Date: 23 March 2018
Your Ref: A/11/OUT and A/23/15/OUT
Our Ref: 9349

OBJECTION TO APPLICATIONS A/11/17/OUT AND A/23/15/OUT RELATING TO LAND SOUTH OF NEW ROAD (A259) AND EAST OF BROOK LANE ANGMERING

Title
HIGHWAY ACCESS PLAN

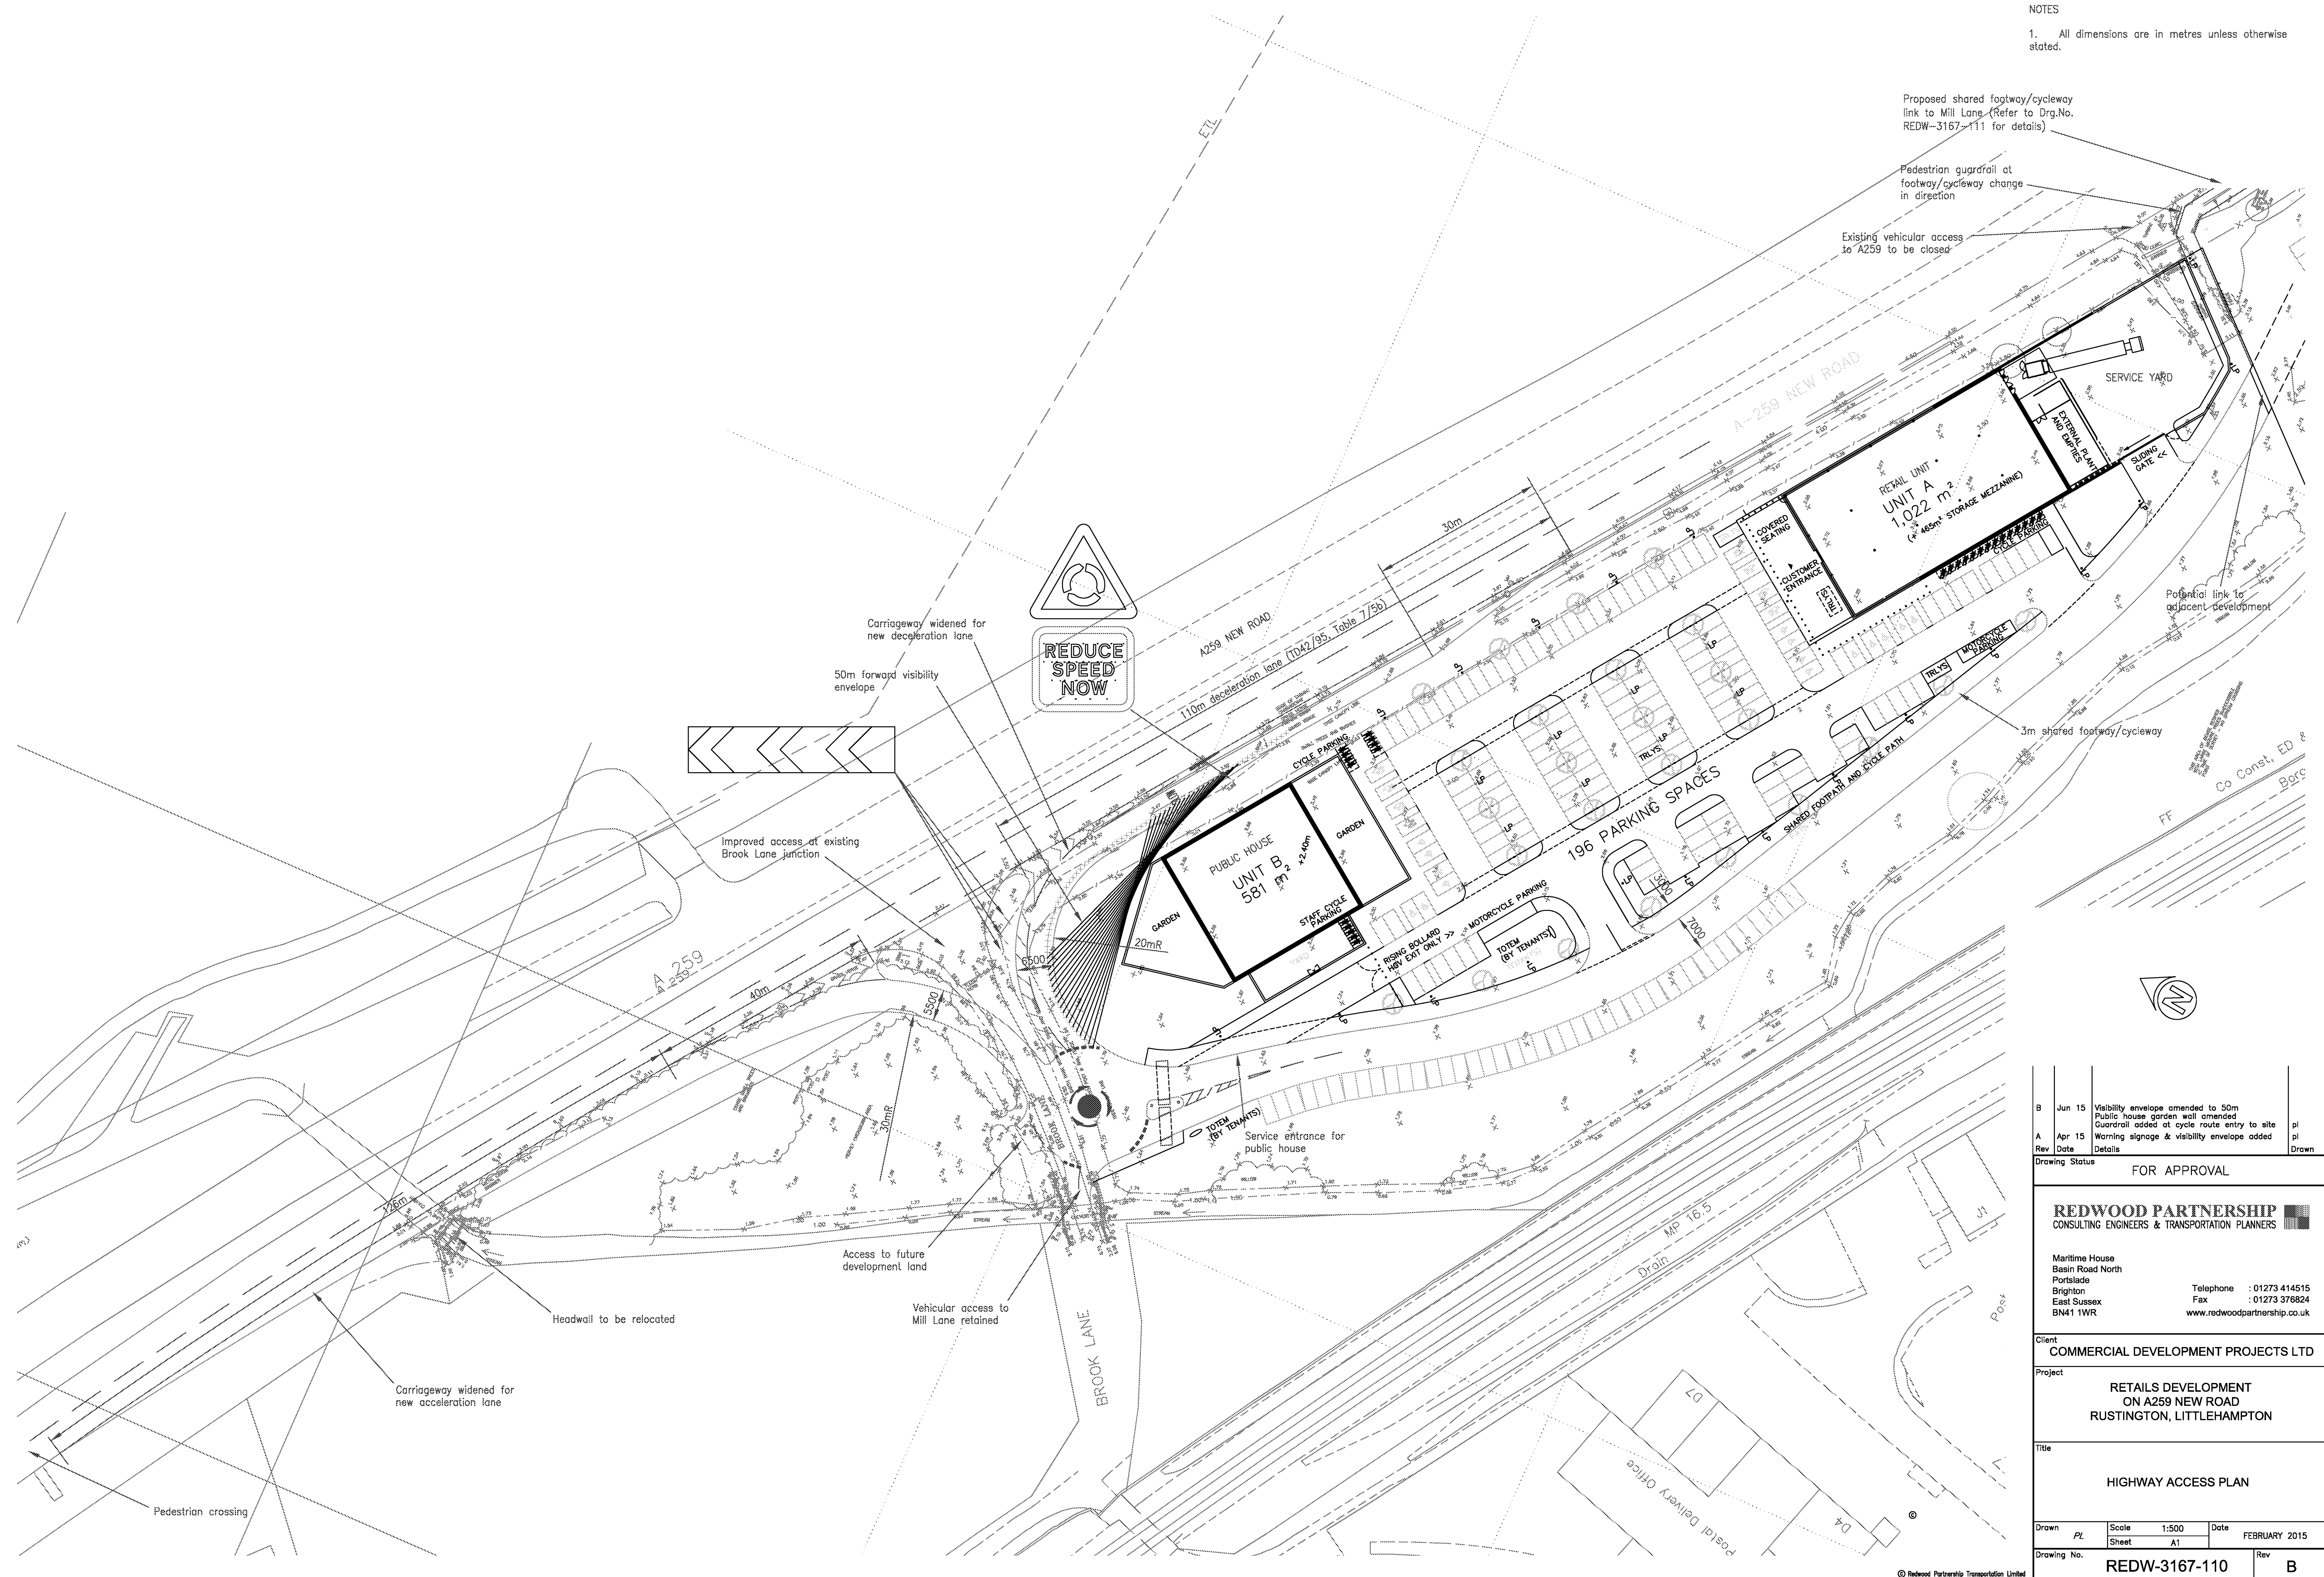
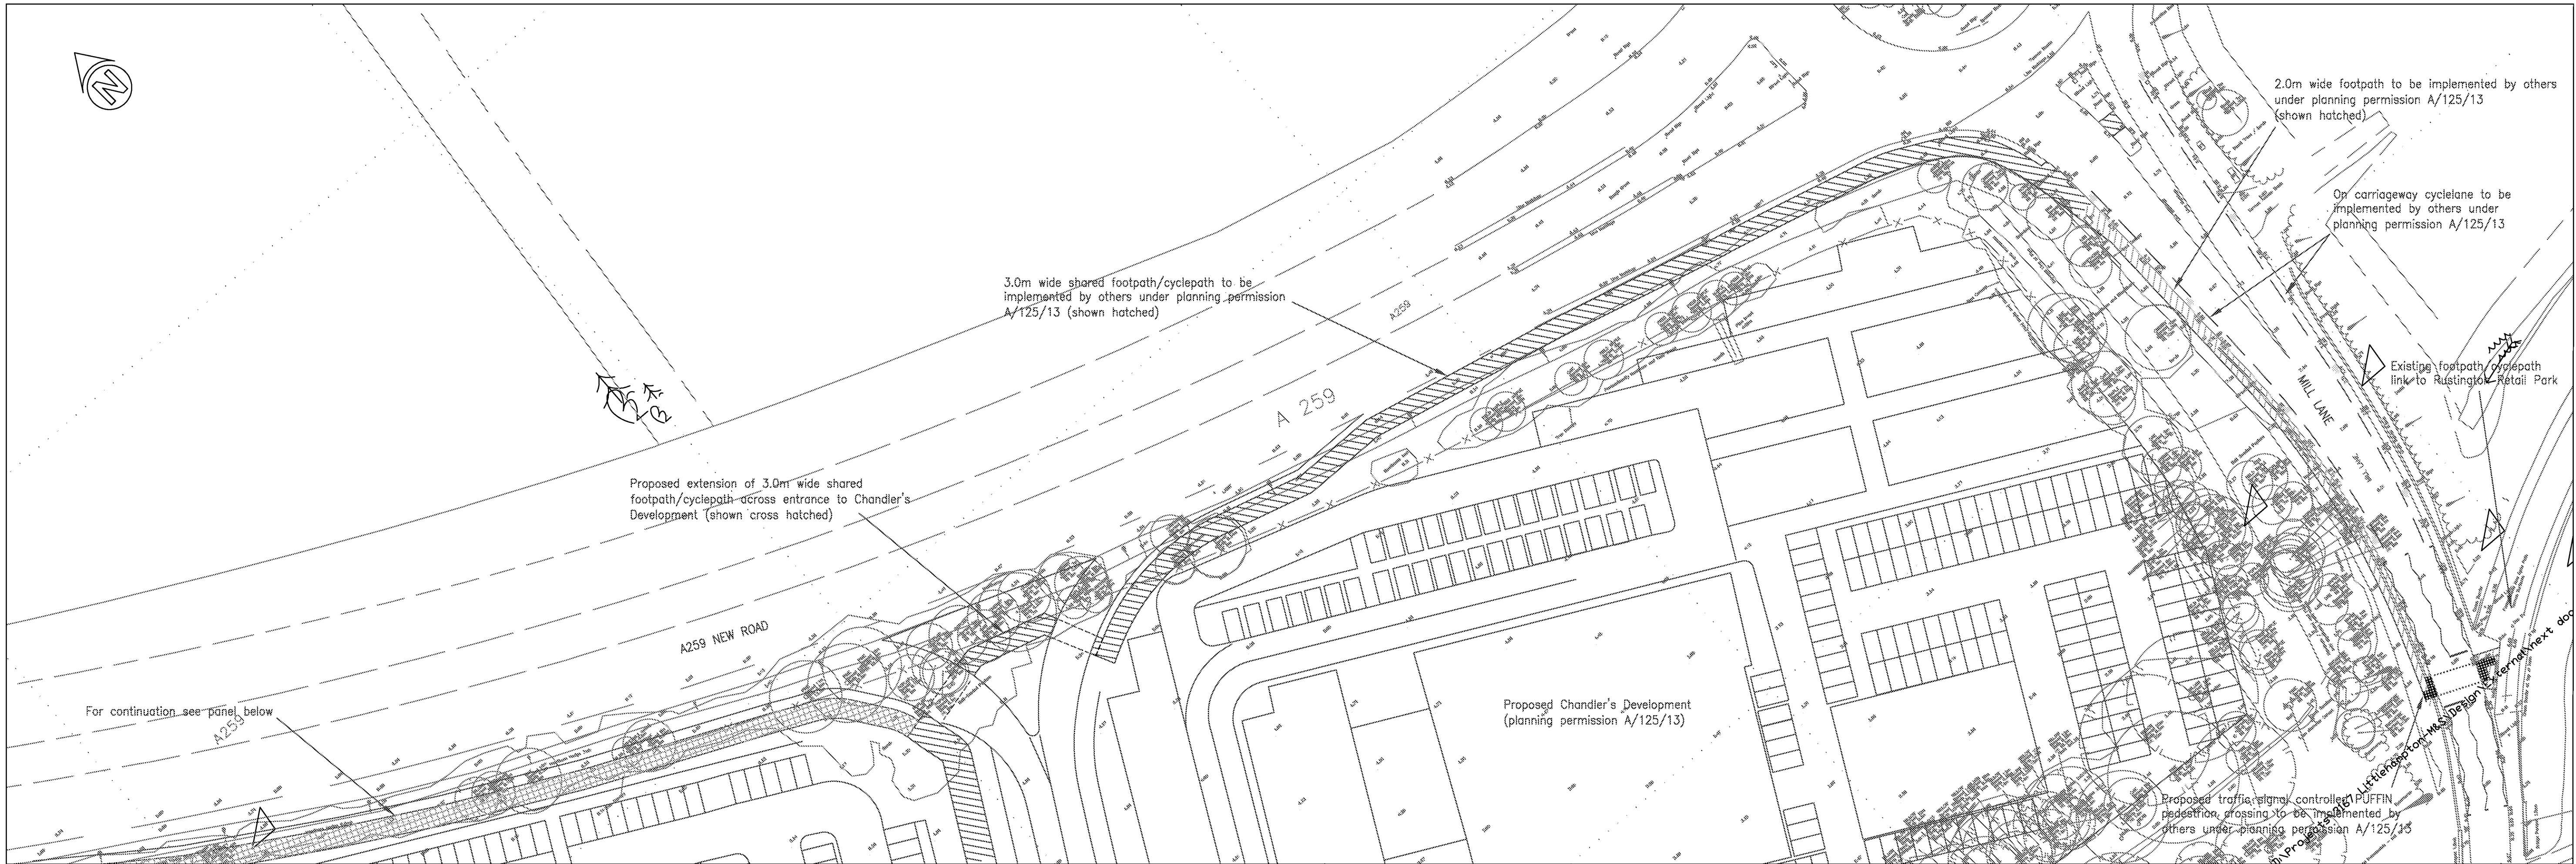
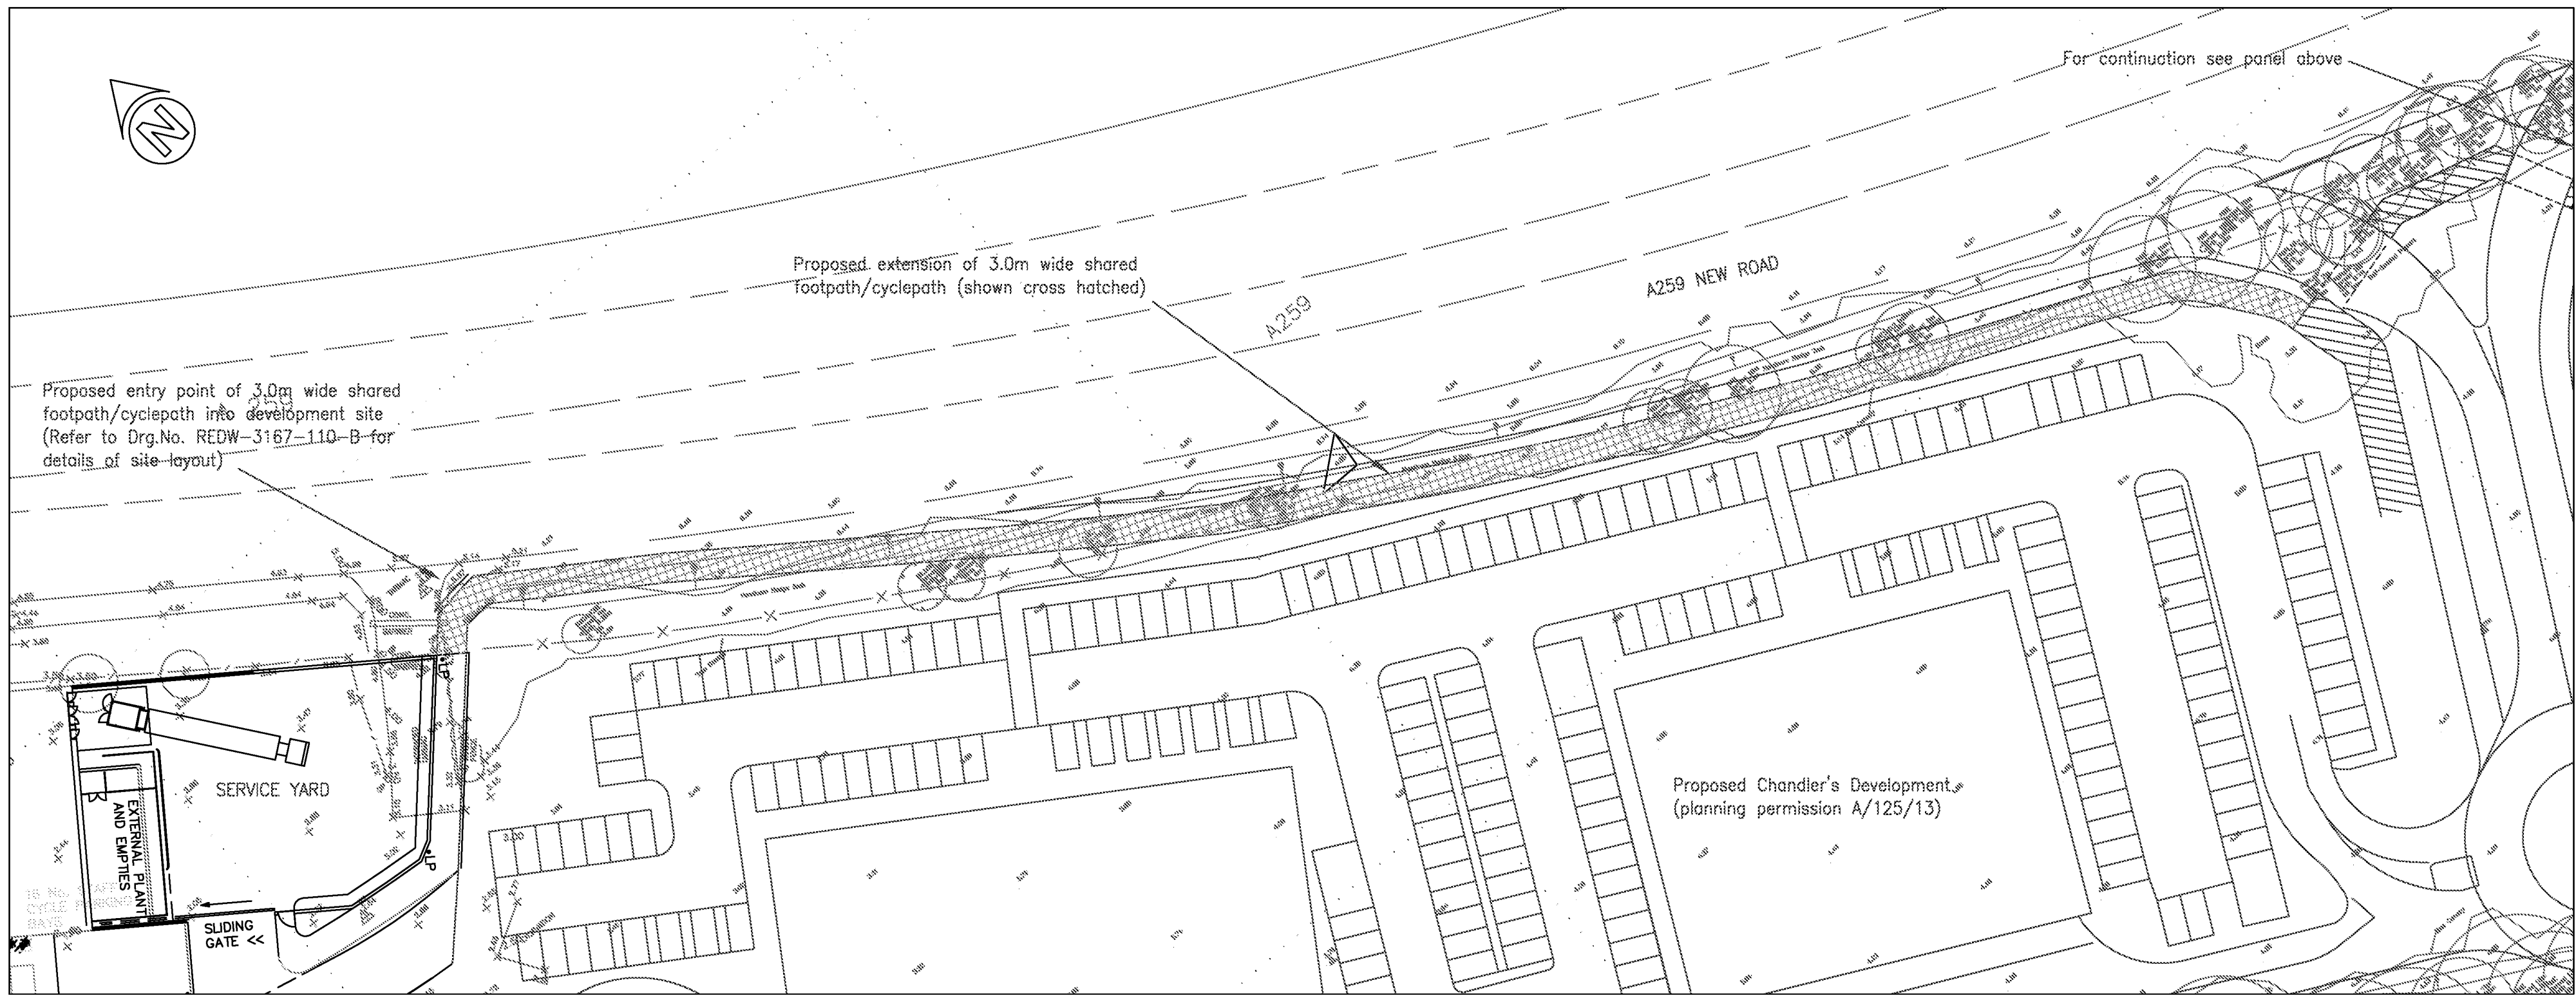
The advice from WSCC is that they would not adopt the internal roads. SDB’s access plan (REDW-3167-131B) therefore needs to be updated as it currently states that the routes would be ‘offered for adoption’. Either the scheme needs to change prior to determination to ensure that adoption is a realistic probability, or the applicants should ensure that the implications of their design are properly understood. In particular, we consider that the access proposed would not be suitable for the residential scheme which is a committed development. A residential scheme of the size proposed on my client’s site would need a road built to the boundary which was at the very least built to adoptable standards. If the road is not going to be adopted, this is likely to reduce the attractiveness of the site to residential developers and therefore threaten the delivery of new homes which would make a valuable contribution to the Council’s housing land supply.
